Our Ref: FG/130/17/HH
Your Ref:

Town & Country Planning Act 1990 (as amended)
Town & country Planning (Development Management Procedure) (England) Order 2015
Application for Planning Permission for Works or Extension to a Dwelling

Development Single storey side extension
Location 35 Meadow Way Ferring

Location Plan. Scale 1:1250

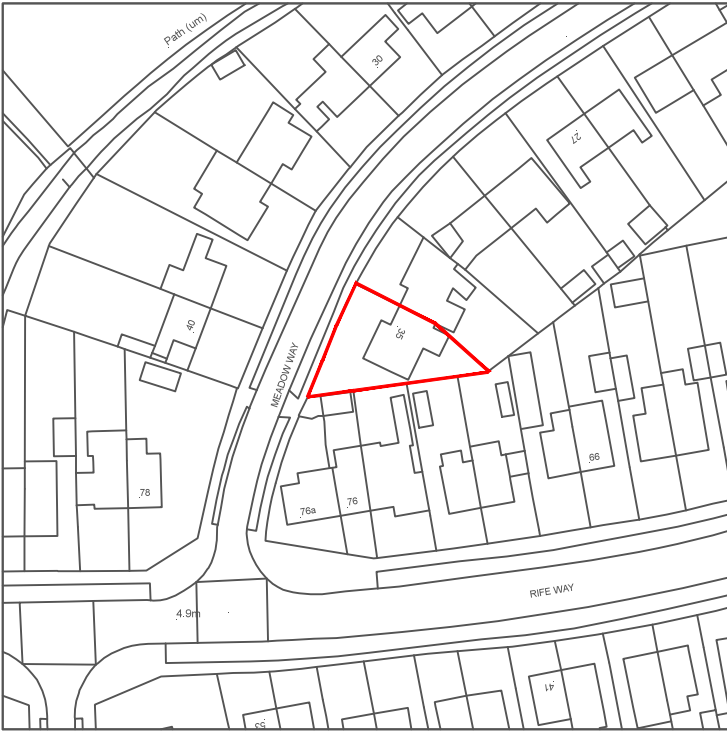
Location Plan Amend

Please submit 1 electronic or 3 paper copies of a location plan at a scale of 1:1250 or 1:2500 for rural areas. Further details of what must be included on the plan can be found in the National Validation Requirements. Please provide one named road.
